September 11, 2020

Project: Luminaria Senior Community / DRB Project Number: PR-2020-004062
Reference: DRB Comments 07.29.2020
Subject: D/P/S (Owner's Agent) Response to DRB Comments

A1 SITE PLAN
1" = 20'-0"
0 10' 20' 40'

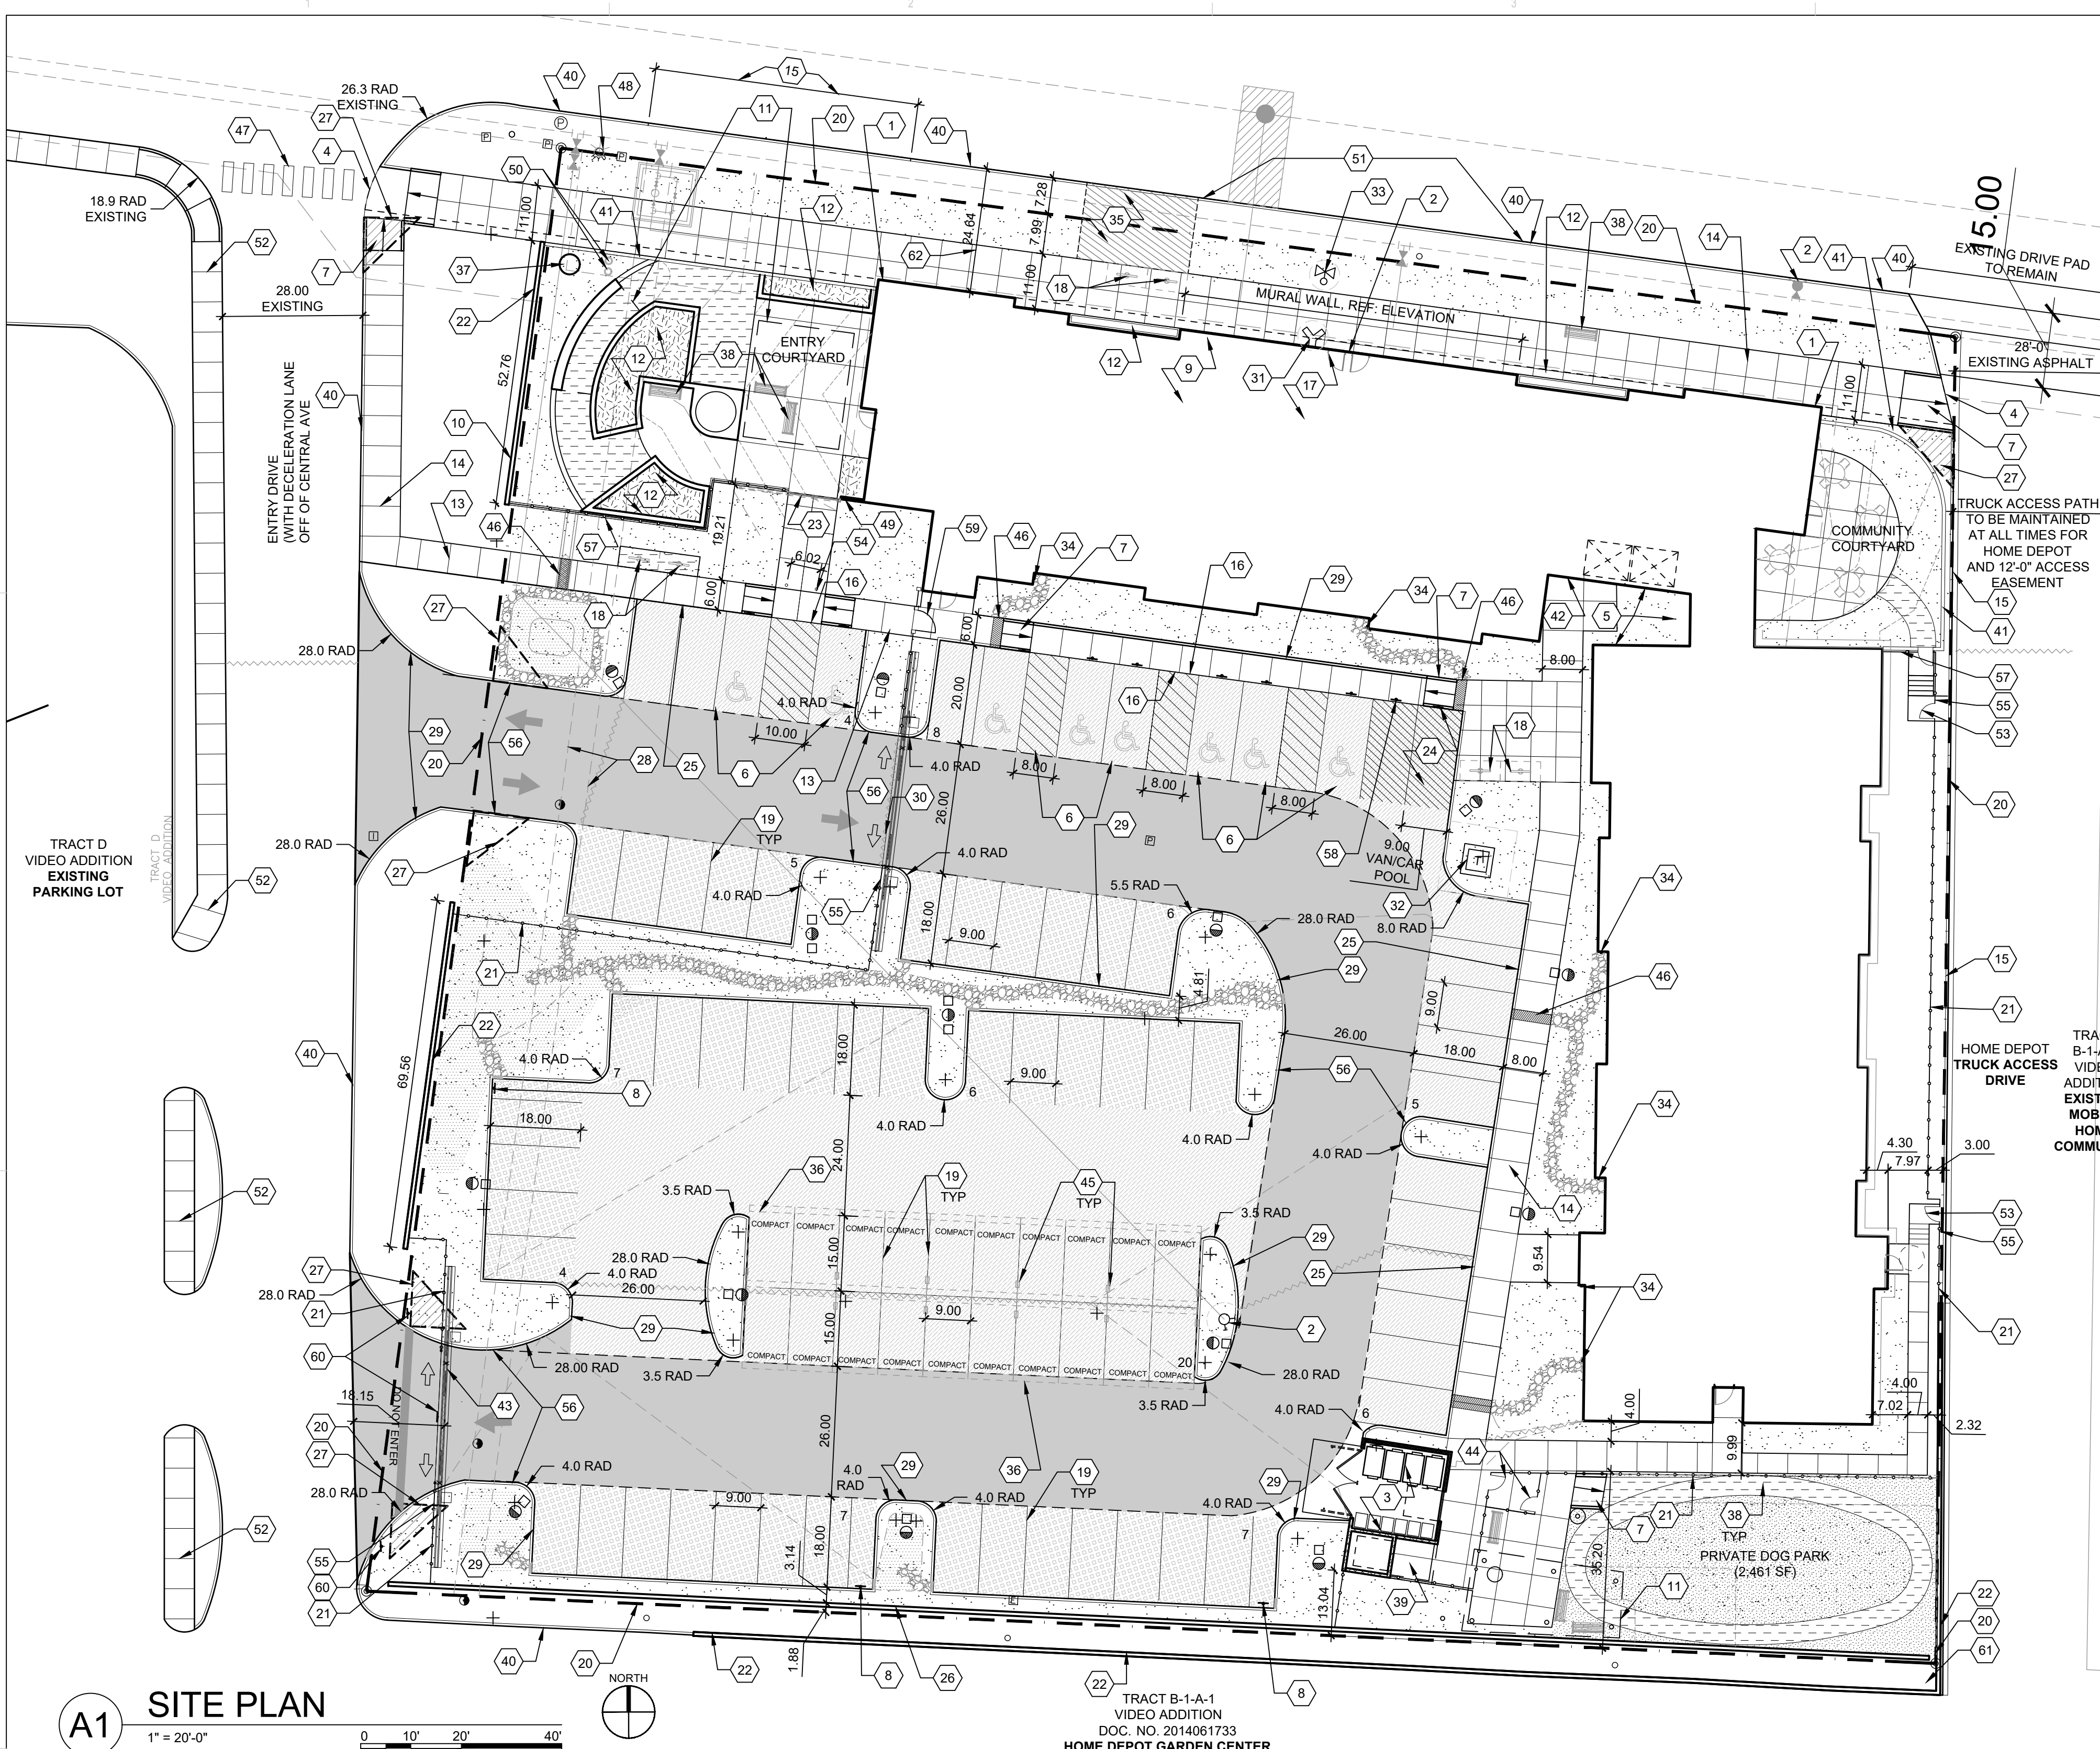
- b. 9/11/2020 – Per email discussion with Jeanne Wolfenbarger, the document provided appears to meet this requirement.
- 2) Clear sight triangles need be shown at entrances to private roadways and at entrances off of Central Avenue. Follow AASHTO standards. Add the note "Landscaping, fencing and signing will not interfere with clear sight requirements. Therefore, signs, walls, trees, and shrubbery between 3 and 8 feet tall (as measured from the gutter pan) will not be acceptable in the clear sight triangle."

- 3) Based on the property line location, it appears that right-of-way dedication along Central Avenue is needed to contain public sidewalk, the bus shelter, and establish sufficient sight distance when pulling out onto Central Avenue.

- a. Clear sight triangles are shown on the Site Plan and Landscape Plan in compliance with requirements.
 - b. Clear sight triangles are shown and keynoted with number 27 on the site plan. The triangles are at both vehicular gates along the west, at the west entry drive and at the Home Depot truck access path along the east aligned with the pedestrian walkway. See snip below for keynote 27.

- 27. CLEAR SIGHT TRIANGLE; LANDSCAPING, FENCING AND SIGNING WILL NOT INTERFERE WITH CLEAR SIGHT REQUIREMENTS. THEREFORE, SIGNS, WALLS, TREES, AND SHRUBBERY BETWEEN 3 AND 8 FEET TALL (AS MEASURED FROM THE GUTTER PAN) WILL NOT BE ACCEPTABLE IN THE CLEAR SIGHT TRIANGLE.

- c.
 - d. Update on 9/11/2020 - A sight mirror has been added to the southeast corner of the site to aid with sight around the corner of the existing wall in the direction towards the truck access roadway towards Central Avenue.

- b. Update on 9/11/2020 - Delineation of the sidewalk easement has been added to the Site Plan, see keynote and notation regarding incorporation of at least 6'-0" of the sidewalk and to the back of curb to be dedicated as a pedestrian sidewalk easement to the City of Albuquerque.
